WELWYN HATFIELD COUNCIL – DEVELOPMENT CONTROL
DELEGATED REPORT

APPLICATION No:	S6/2012/0096/FP
APPLICATION Site:	9 Wilkins Green Lane, Hatfield

The proposed development would involve the erection of a large two-storey extension which would have accommodation within the roofspace. To the rear of the existing property a section of the property would be demolished. To the front of the property two dormer windows would be positioned within the front plane of the roof. A detached garage would be sited to the western flank of the dwelling.

TITLE  
 PROPOSED  
 SECOND FLOOR & ROOF PLAN

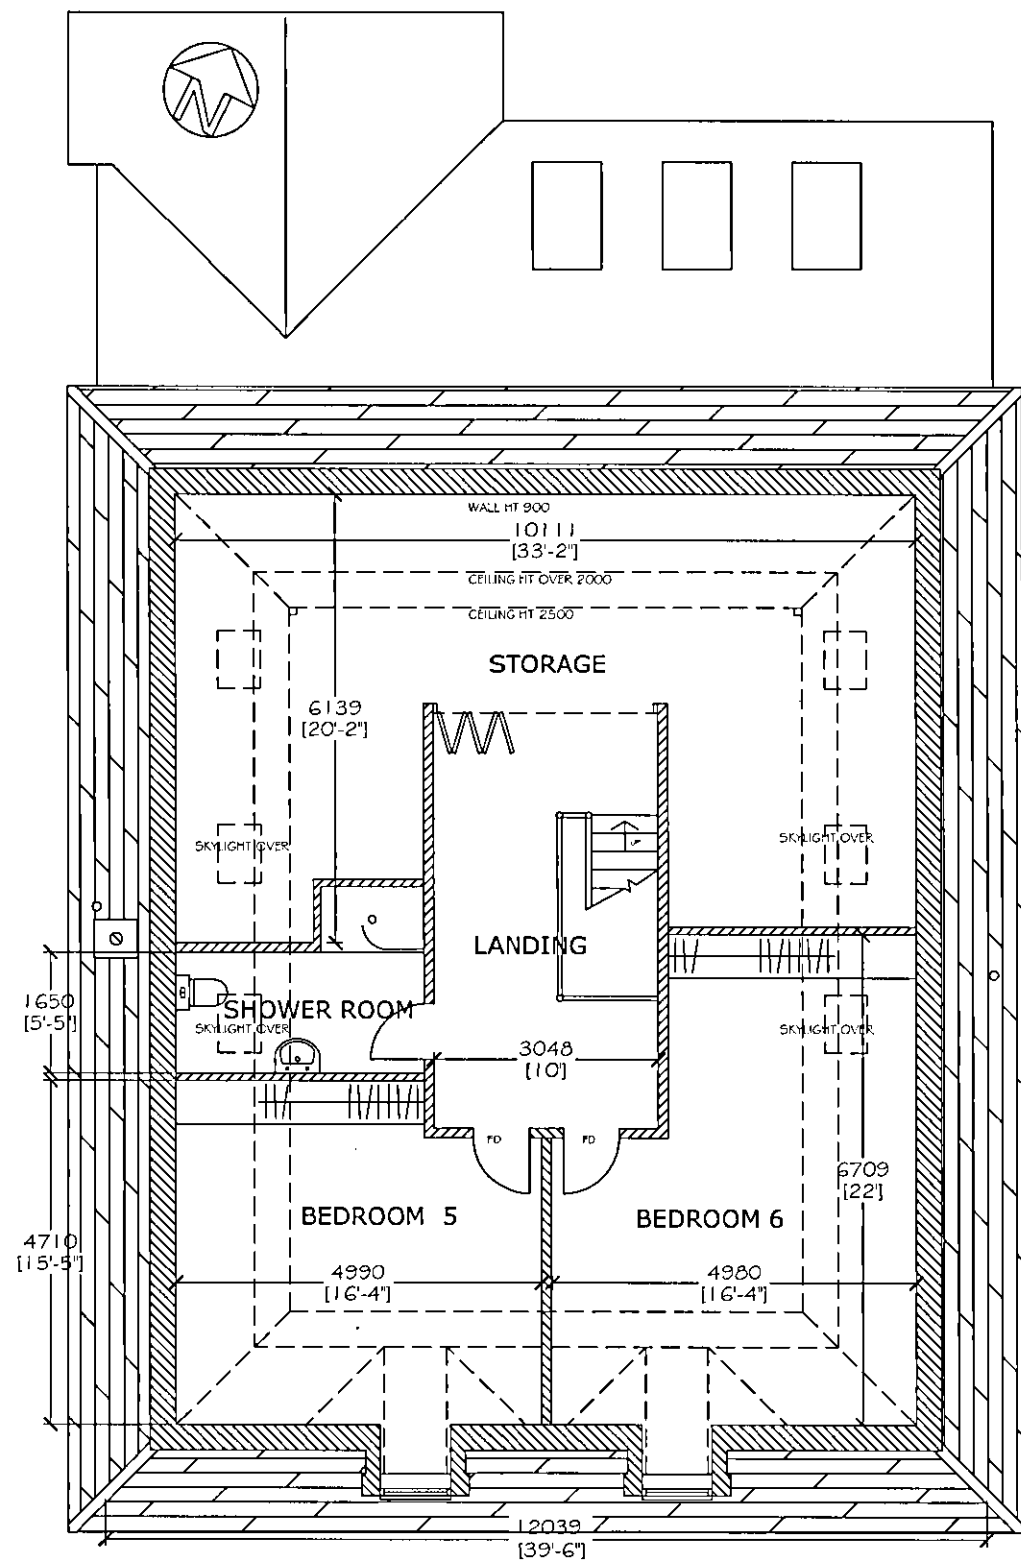
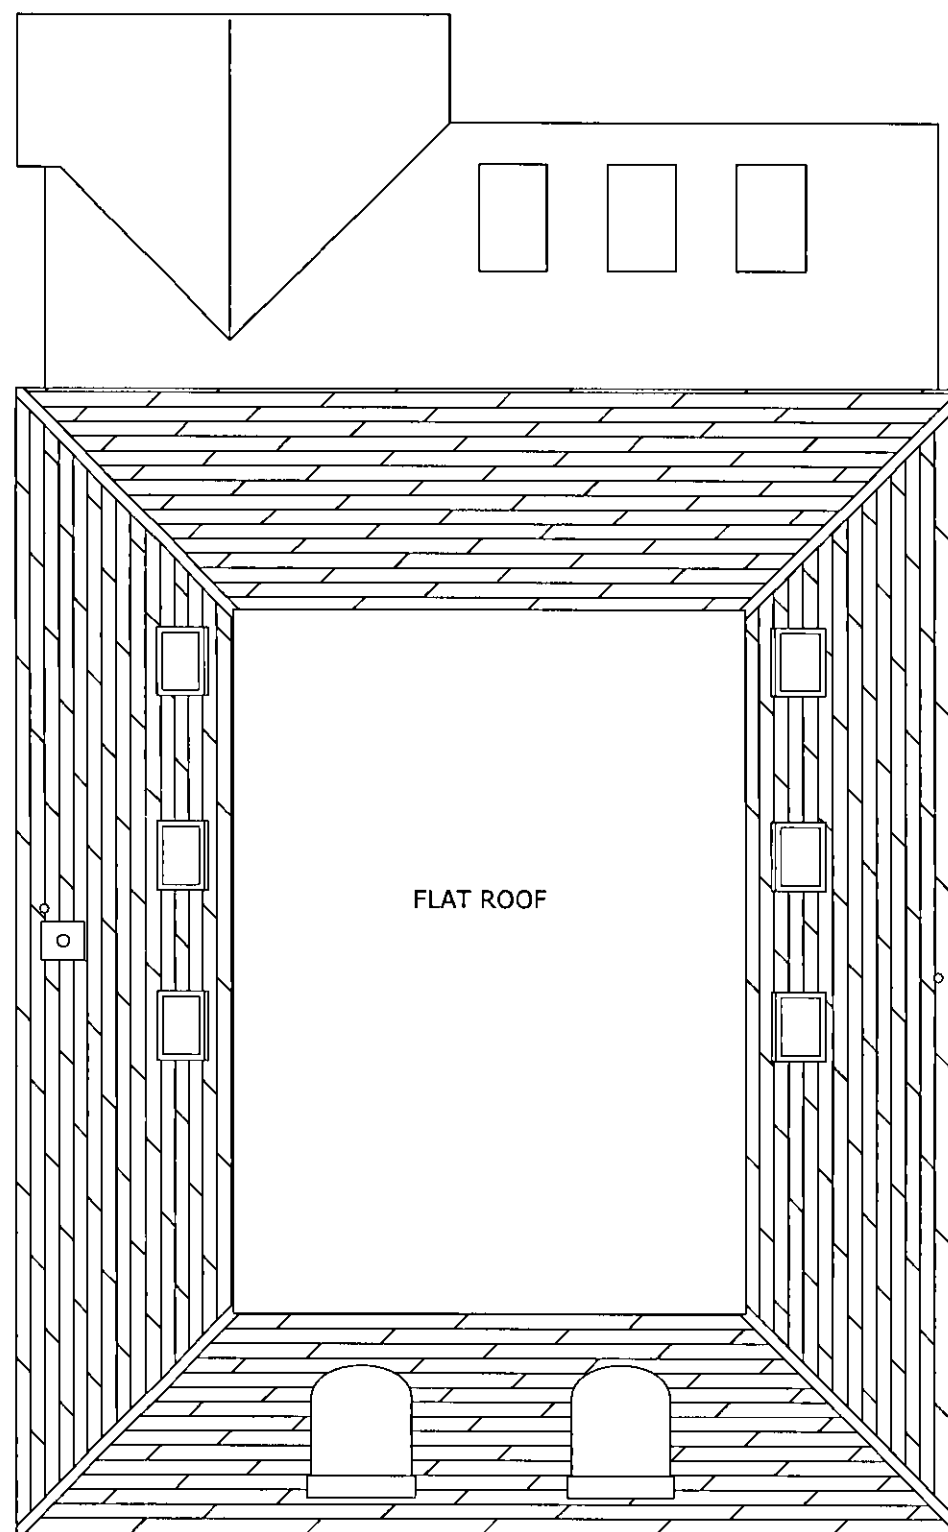
The proposal's depth would be significant and although it is accepted that the existing property has a relatively large footprint and depth, this is often the case with bungalows, and two-storey properties usually have very different proportions. Due to the depth of the proposal at first floor level a large flat roof is required to prevent it from being excessively tall. As a result the proposal would appear bulky, boxy and dominant which is not a feature of the surrounding dwellings and this would not achieve an acceptable standard of design.

The existing dwelling is set forward of the adjacent dwelling to the west (no 10) and the proposed development would all be to the front of this adjacent property. The western flank wall of the proposal would have a depth of approximately 14m at first floor level and the large flat topped roof would give the property a bulky overly dominant appearance. When accessing number 10 the resultant dwelling would appear overly prominent and out of proportion with the scale of dwelling within this area. Glimpses of the additional depth at ground floor level would worsen the appearance of the dwelling and its excessive depth. The resultant dwelling's prominence and odd appearance due to the excessive depth and large flat roof would not respect the character and appearance of the locality.
